OUR REF: 603069-01000

**Re: 594 Rideau Street – Transportation Brief
Addendum #1**

This Addendum has been prepared to address the comments received from the City of Ottawa with corresponding responses from Parsons.

RIDEAU STREET

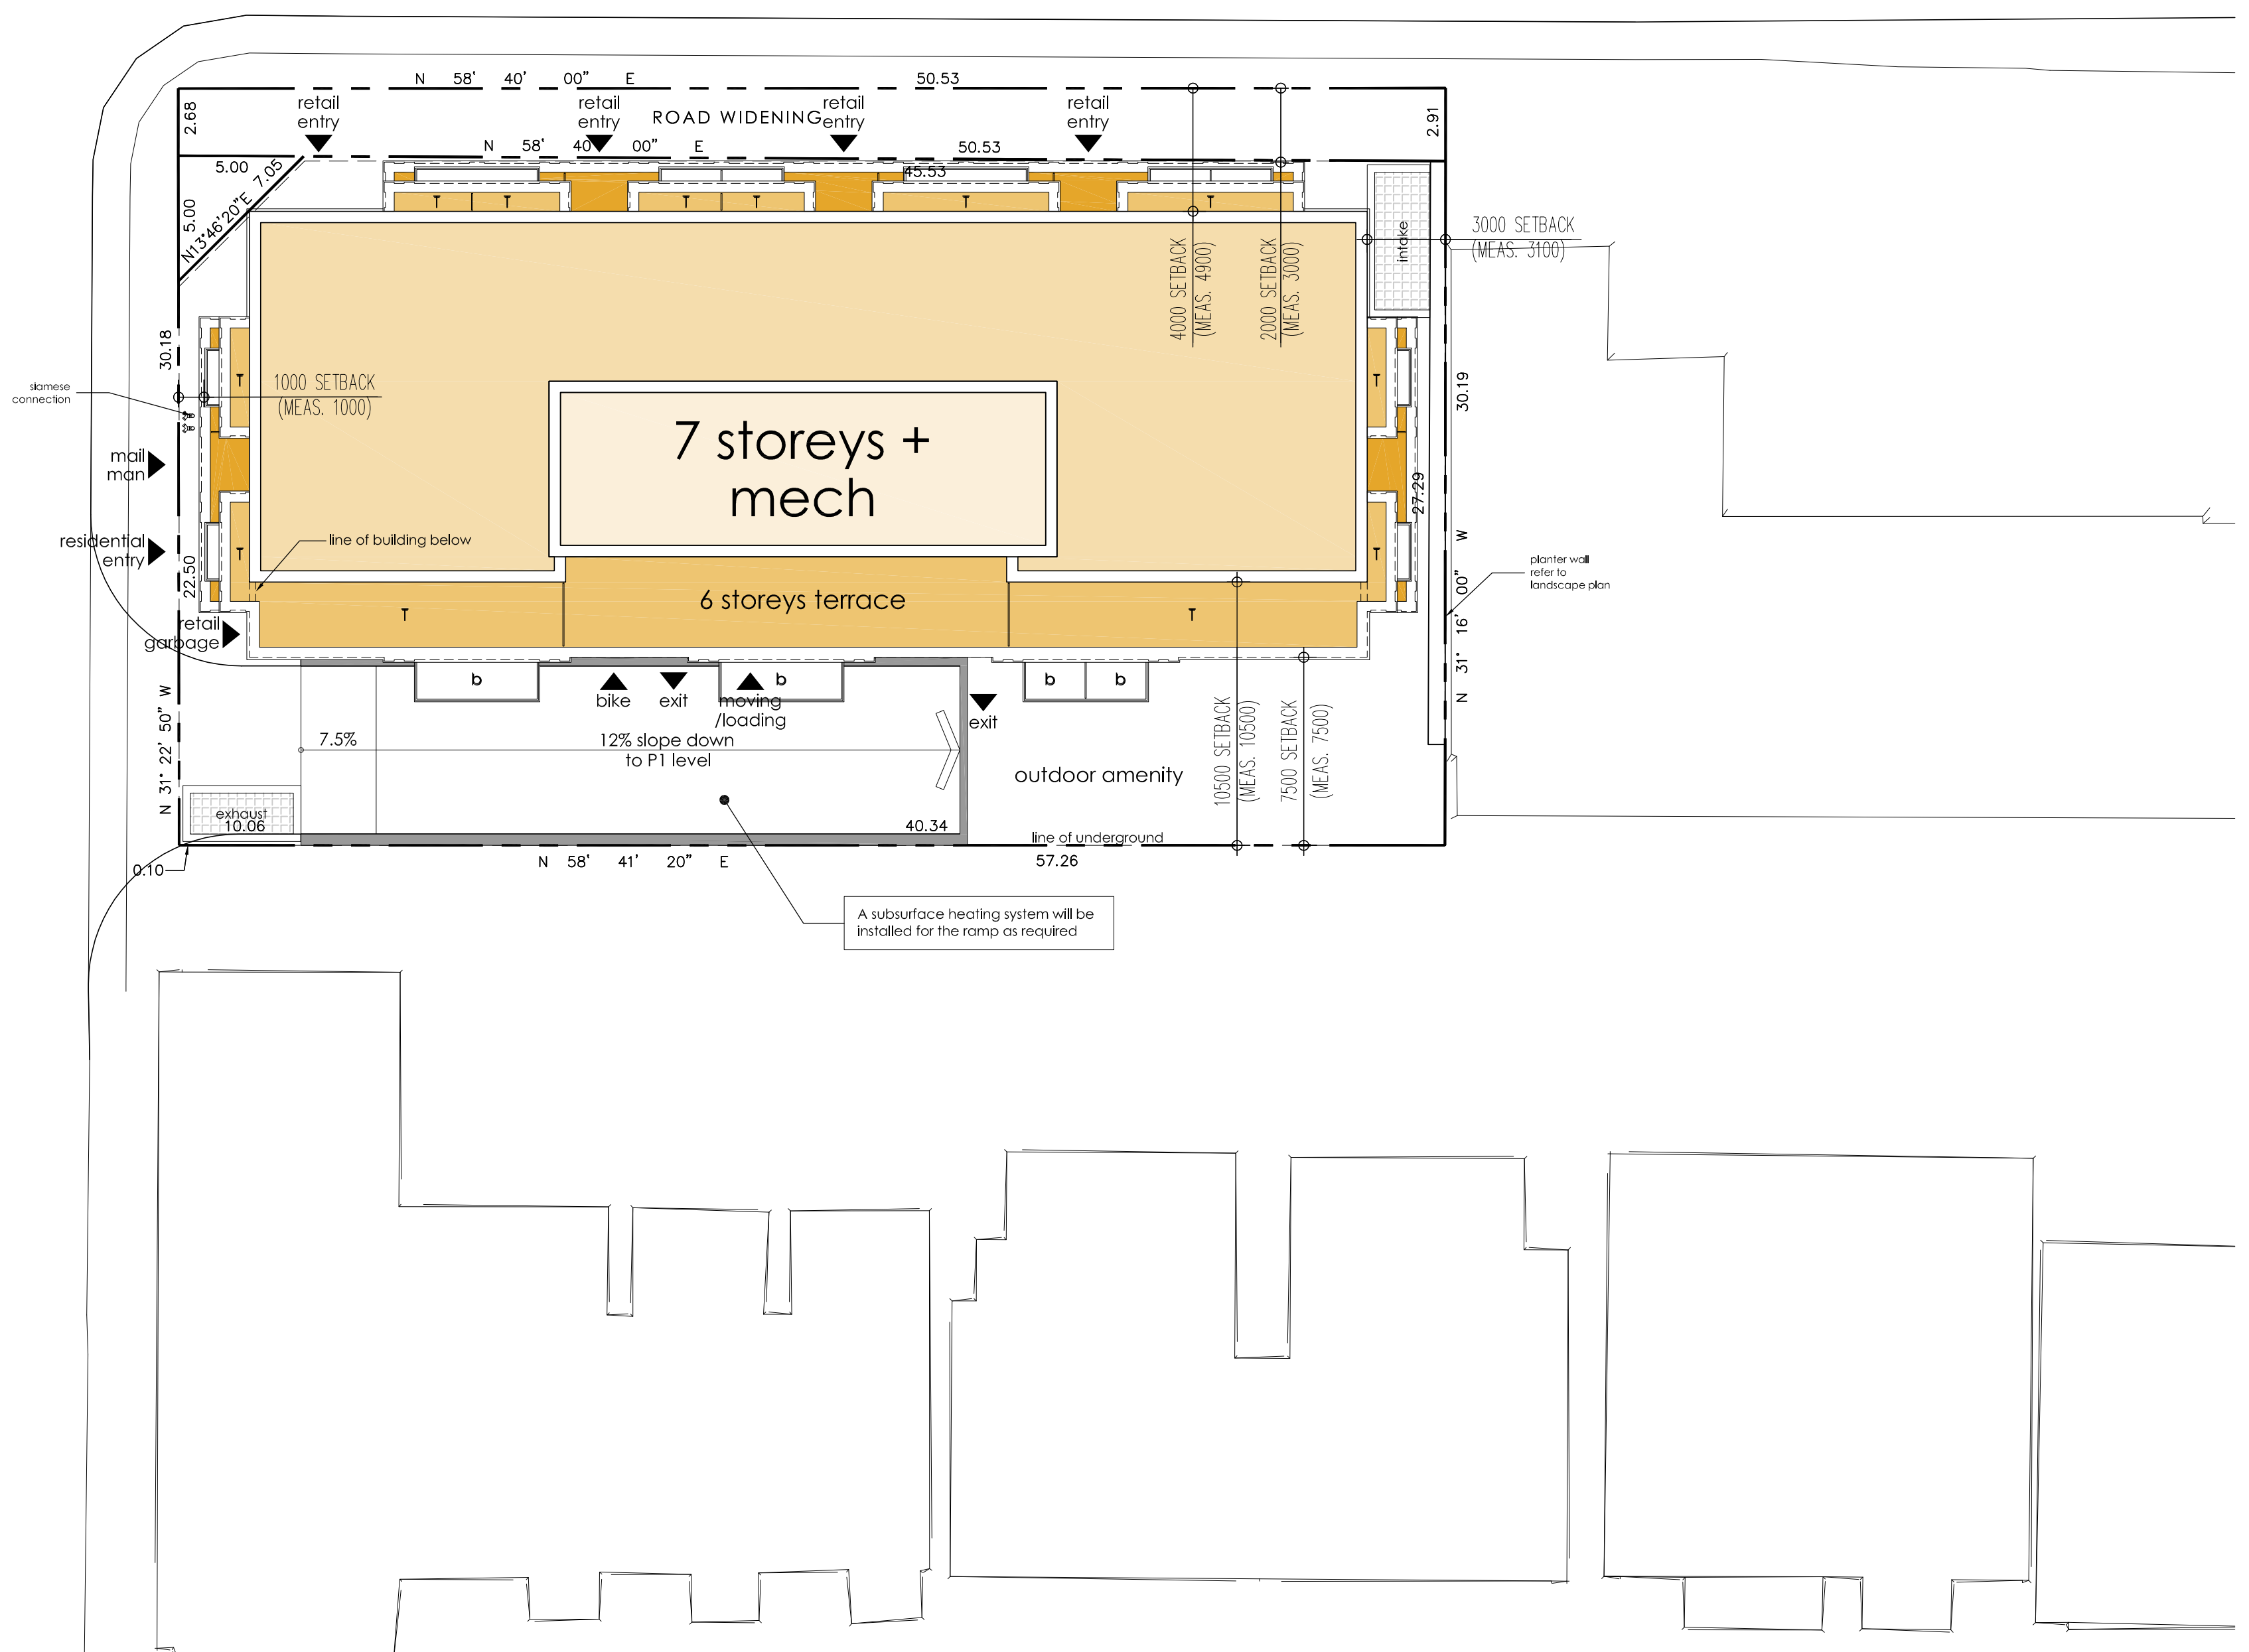
Comment 11: *There is a bus stop (#7590 – Rideau/Charlotte) located west of the site along eastbound Rideau Street, west of Charlotte Street. We would recommend that the bus stop location be adjusted to the east of its current location so that the bus stop is located on the far side of the Rideau/Charlotte signalized intersection. Studies have shown that stop times at far side bus stops, are, on average, 4.2 to 5.0 seconds faster than stop times occurring on the near side of intersections. Please refer to the attached diagram for the suggested bus stop and shelter location. The applicant shall construct a new concrete shelter pad at no cost to the City, as per City specification SC-11 attached, in order to allow for the relocation of the loading area and shelter. The Site Plan should be revised to show how this bus stop and shelter will be accommodated.*

Comment 13: *What happens to southbound movements when northbound vehicle block the access to the site? Please verify the potential impact on transit operations when this occurs. Appropriate road design should be recommended over traffic signage, and as such, consideration should be given to providing a right-in/right-out access to the site instead of a full movement access.*

Comment 16: *No private approach shall be constructed within 0.3 metres of any adjacent property measured at the highway line, and at the curb line or roadway edge.*

Comment 17: *Ensure that the end of the curb return at the proposed driveway does not encroach within the frontage of the adjacent property.*

Comment 19: *Right turn in/right turn out only on Charlotte Street.*

Comment 20: *Parking restrictions on west side of Charlotte Street during peak periods to allow southbound through vehicles to bypass left-turning vehicles at the proposed access.*

Response 11: The proponent has been advised and understands the transit impacts and analysis. However, the proponent has no plans to accommodate the relocation of the existing bus stop along the frontage of the proposed site.

Response 13: Given the existing road geometry, if a vehicle is waiting to turn left into the site, southbound vehicles can bypass this vehicle in the adjacent curb lane. On-street parking/stopping is currently restricted during the morning peak period in the southbound curb lane between Rideau Street and Besserer Street. It is recommended that this restriction be implemented for the afternoon peak period as well to ensure there will be sufficient space for southbound through vehicles to pass left-turning site-generated traffic.

Response 16: Noted and the architect has been advised.

Response 17: Noted and the architect has been advised.

Response 19: Given the urban location of the site and the low traffic volumes projected to access/egress the site, a full movement driveway is recommended.

Response 20: Agreed. There is a current 'no stopping' restriction along Charlotte Street during the morning peak period at this location. Extending this restriction to include the afternoon peak period is recommended.
